**[PR-2021-004967](#)**

**MINOR\_PLT-2025-00019 – PRELIMINARY/ FINAL PLAT**

**DHOWVR-2025-00013 – SIDEWALK WAIVER**

**JAG PLANNING & ZONING | JUANITA GARCIA** agent for **JOE P GRADY** requests the aforementioned action(s) for all or a portion of: Tract 107-A-2-A & Tract 107 A-1-A-1, MRGCD Map 31 zoned R-A, located at **3815 PEDRONCELLI RD NW** between **RIO GRANDE BLVD NW AND ELFEGO RD NW** containing approximately **1.2324** acre(s). **(F-13)**

PLAT OF LOTS 1, 2 AND 3  
LANDS OF JOE GRADY

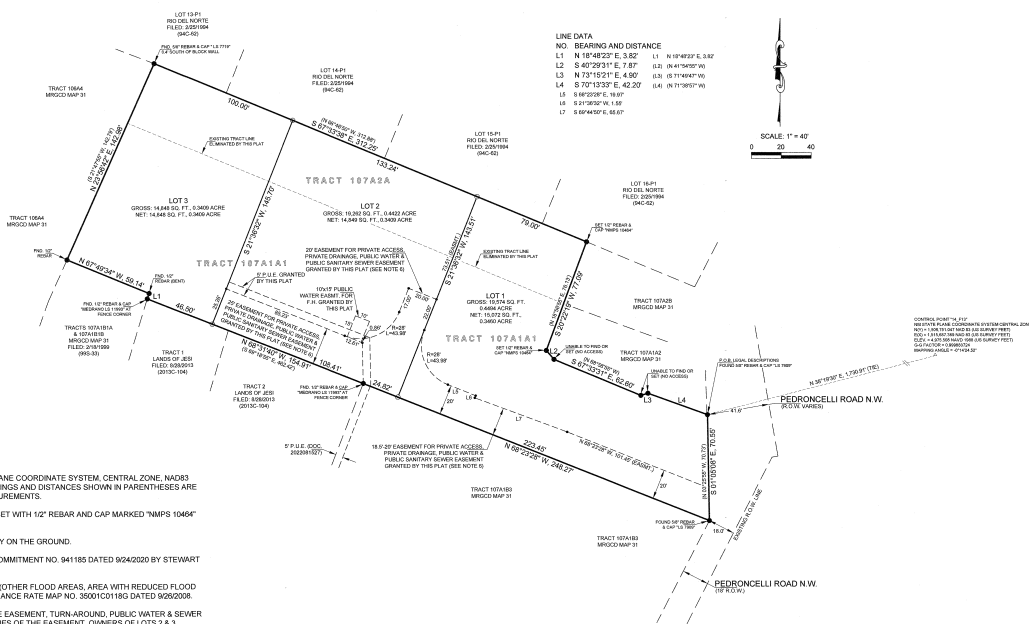
1. Variance obtained for contextual lot size, VA-2024-00056. Must include variance in notes on final plat, as the variance affected the approval of the proposed lot sizes, accordingly, as per IDO 6-6(O)(2)(f):  
“Any Variances granted that are associated with a Site Plan or other approval shall be noted on the approved Site Plan or other approval.”
2. Code Enforcement has no further comments and no objections.

1. Transportation has no objection to the waiver for sidewalk, curb and gutter. Though, Transportation does not agree with some of the language used in explanations for criteria 1a and 3 which reference drainage as this is the responsibility of the applicant to prove. Transportation agrees to the waiver but asks that these items be not considered as part of the approval.
2. Transportation has no objection to the determination for the ROW width or private access width.
3. As a condition for approval, please provide dimensions of the alternate hammerhead to ensure it meets Fire standards for a turn around.

- Per 6-6(K)(2)(I) of the IDO, the applicant shall record the Plat with the Bernalillo County Clerk within 3 months after the date of the final signature on the Plat, or the subdivision shall be voided.
- A note must be added to the Plat regarding the request (approval) of this waiver from the Development Hearing Officer (DHO) to allow no sidewalks, curb or gutters along Pedroncelli Rd NW.
- Per Table 6-4-3 of the IDO, a Sidewalk Waiver expires within 1-year if not platted and expires with associated Site Plan if approved by the DHO.

- The applicant is requesting that the DHO approve the existing right-of-way (ROW) width of 18.6 feet at its narrowest point rather than the 22-foot width typically required by the Development Process Manual (DPM) – due to current site development constraints. The proposed access easement will serve three dwelling units. Planning staff defer to Transportation staff on this Determination.
- The applicant states that the request meets approval criteria, since an existing garage prevents expanding the easement to the standard width.
- A note must be added to the Plat regarding the request (approval) of this determination from the Development Hearing Officer (DHO).
